## Appendix A – Detailed record and response to submissions and additional information

Extracts from Government agency and authority submissions received in relation to SSD 10479, and a response to each of these matters, has been outlined in the table below.

36.5m B-TRIPLE TURNING PATH PLAN
1:250

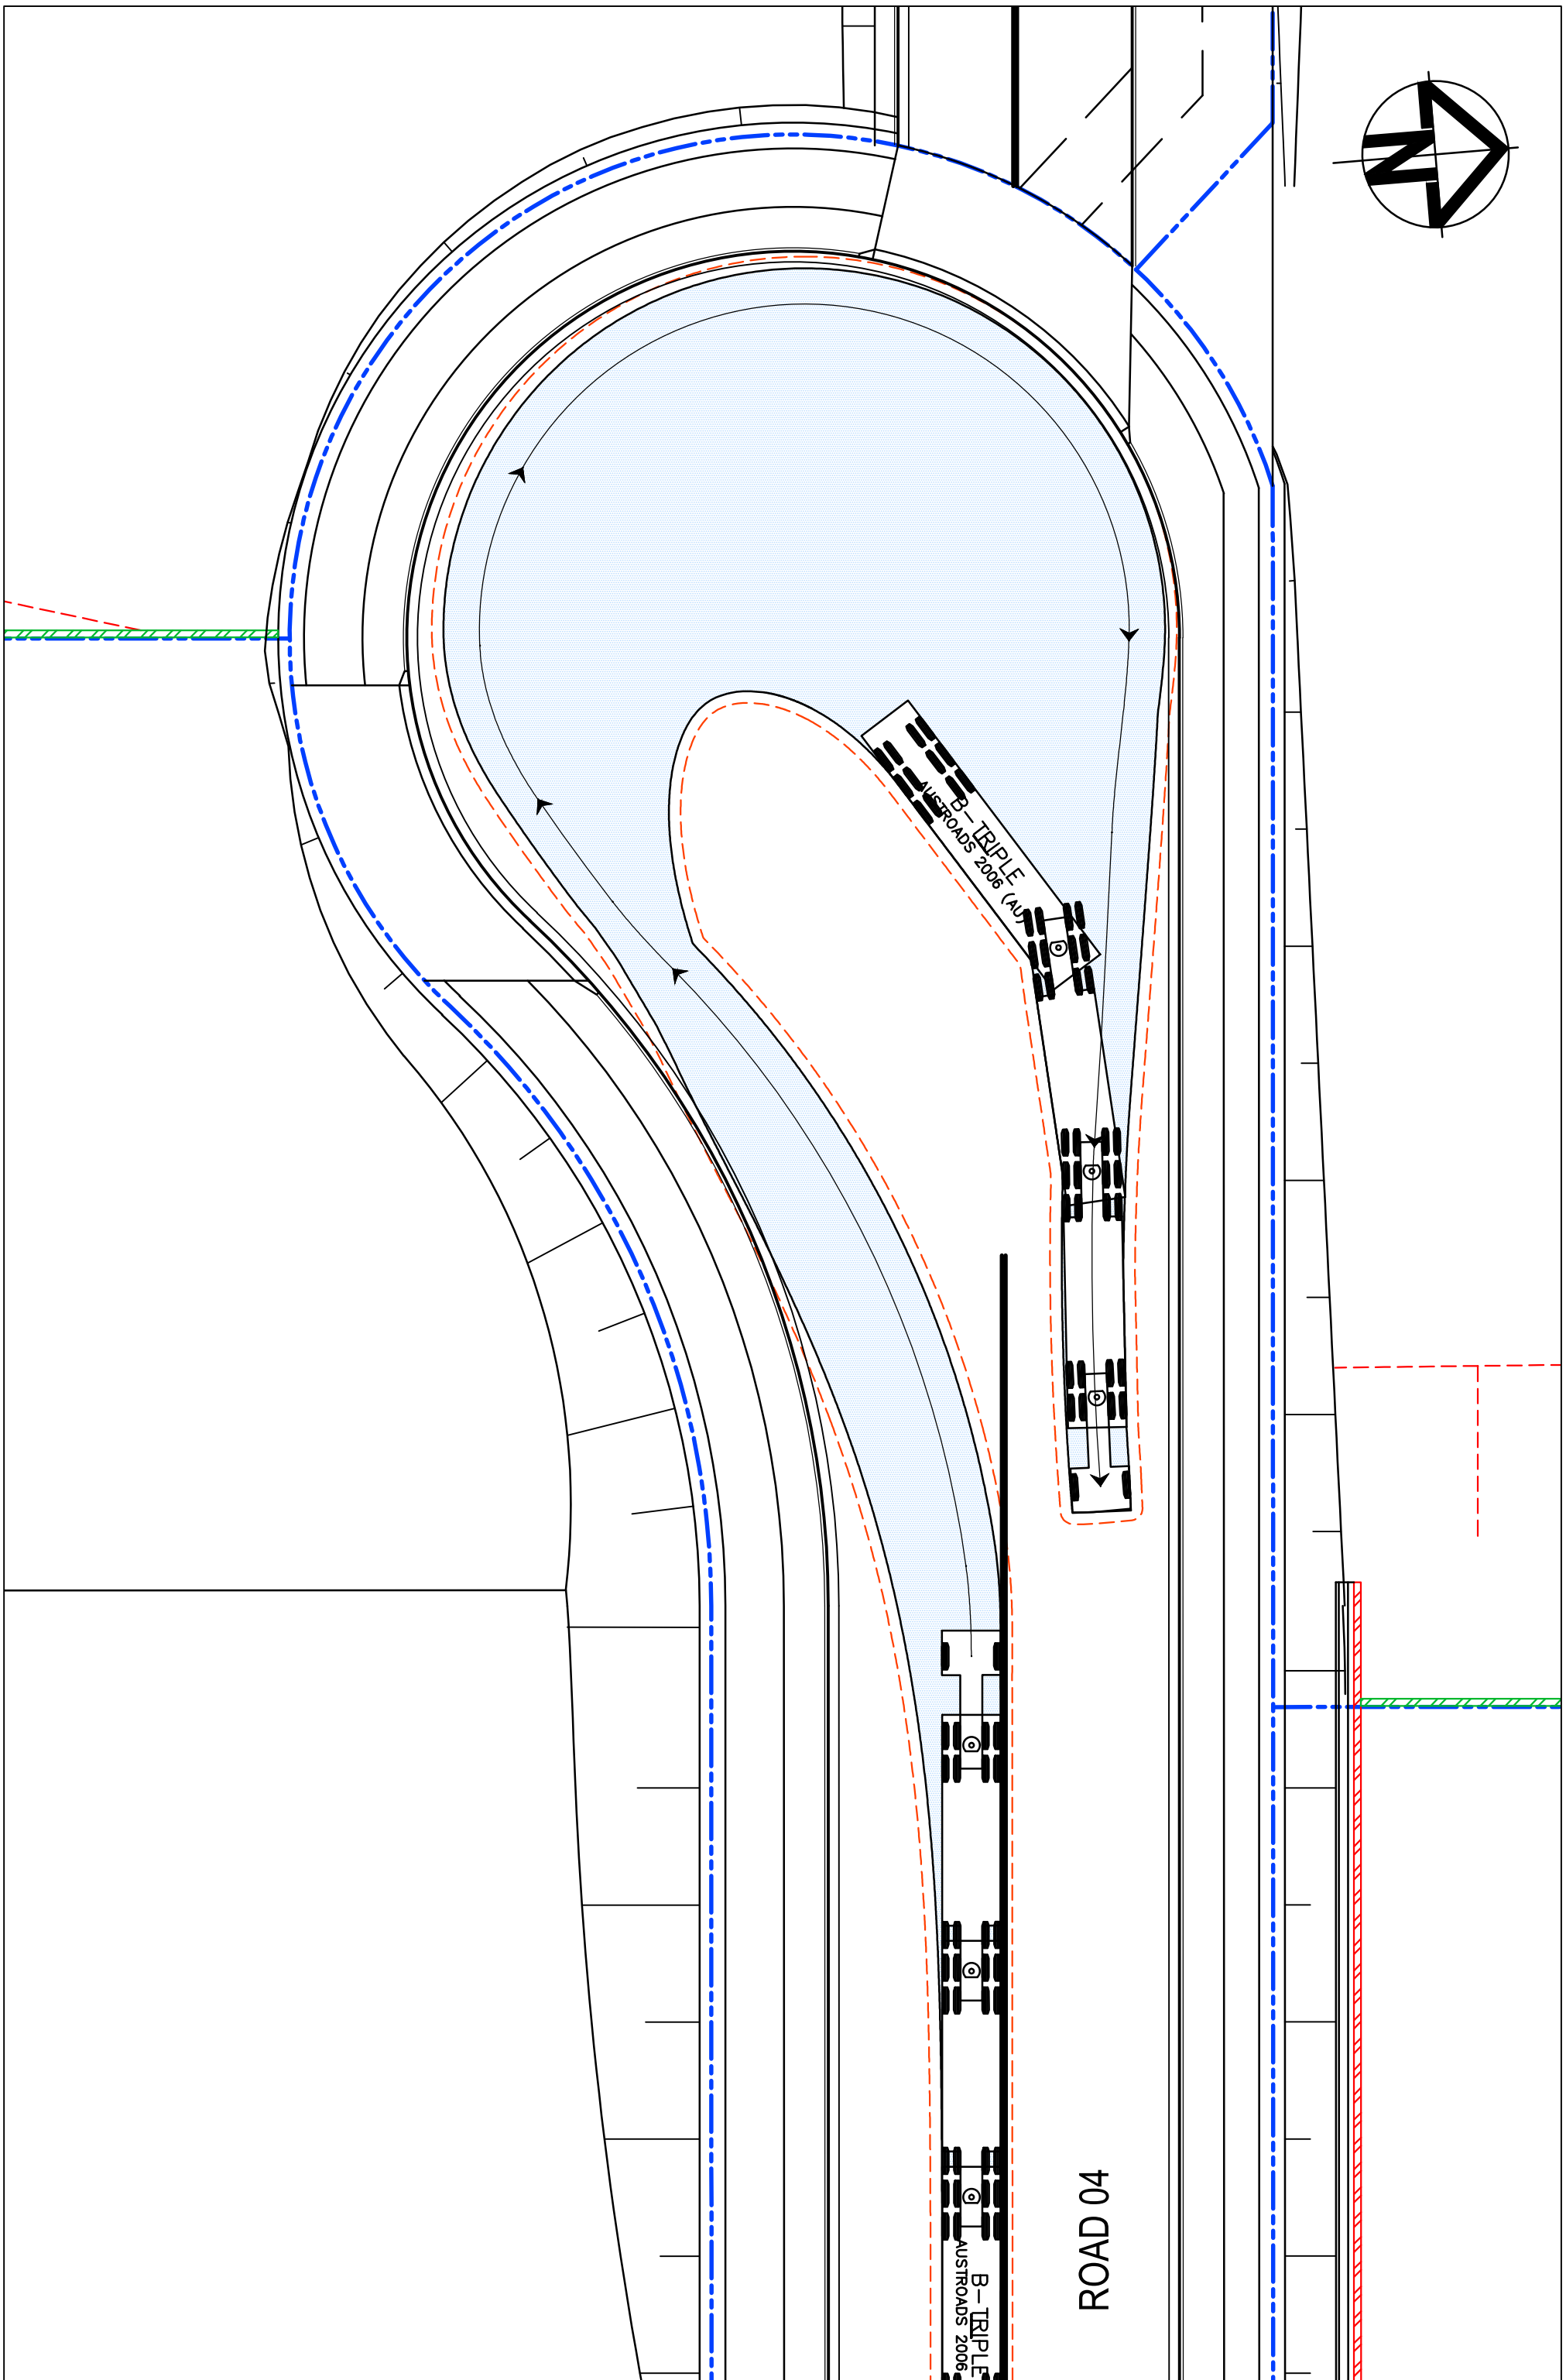
<p>Appendix Z - Civil Drawings - Intersection (1) &amp; (2) – Turning path plans are provided for 30m PBS type 2B. According to the Draft Mamre Road Precinct DCP Road design item (16), it should be tested for 36.5m PBS Level 3 type A vehicles.</p>	
<p>TfNSW requests the abovementioned information to be addressed/provided for further assessment prior to the determination of the application. TfNSW will further review and provide response upon receipt of the additional information</p>	
<p>TfNSW notes that the applicant has provided a Framework Sustainable Travel Plan. In their previous submission TfNSW advised that the applicant prepare a Green Travel Plan in consultation with TfNSW for the warehouse and ancillary office buildings proposed for Lot F. The applicant shall submit a copy of the final plan to TfNSW for endorsement prior to the issue of the first occupation certificate</p>	Noted.
